**Subject:** Comments on Planning Application 3/202/0647

Consultation on planning application 3/2020/0647 land  
adj 142 Ribchester Road, Clayton le Dale BB1 9EE

Title:
TREE PROTECTION PLAN
In Relation to Proposal to Construct Field Access Track

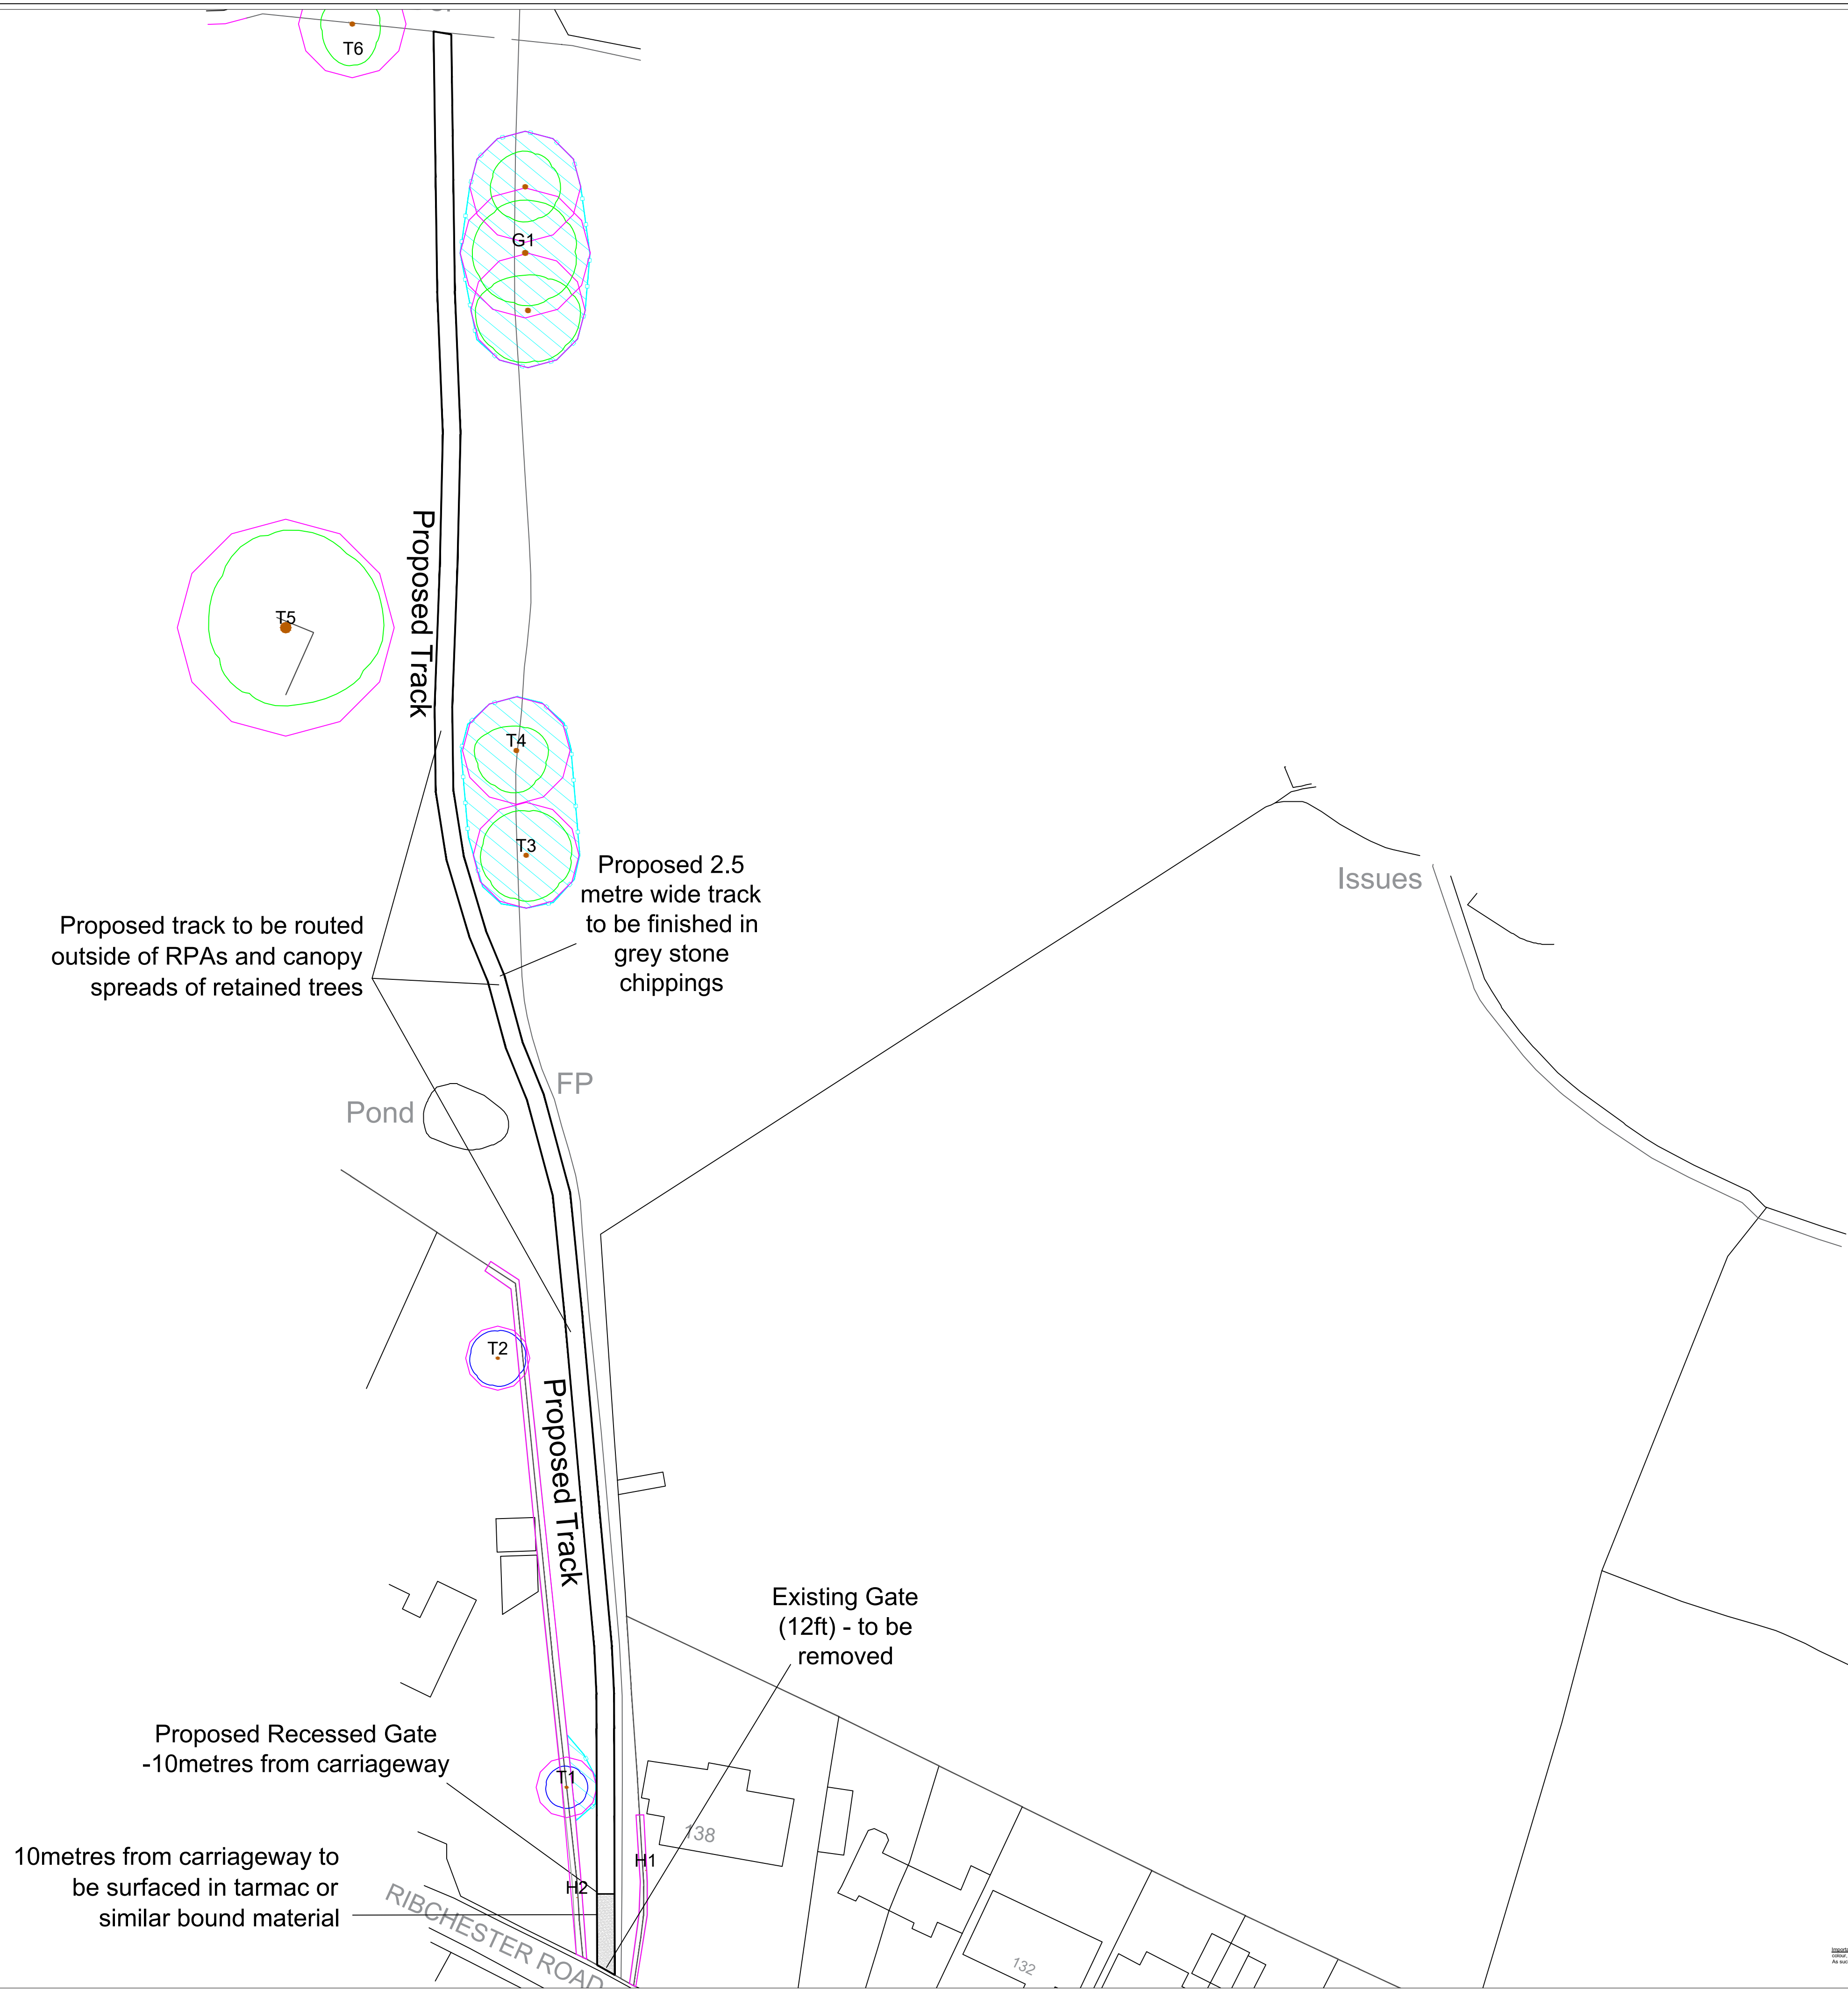
Salesbury Parish Council have no objection to the above application, however, note that part of land of the proposed track is lined with trees and would ask that these are not damaged in the making of the track.
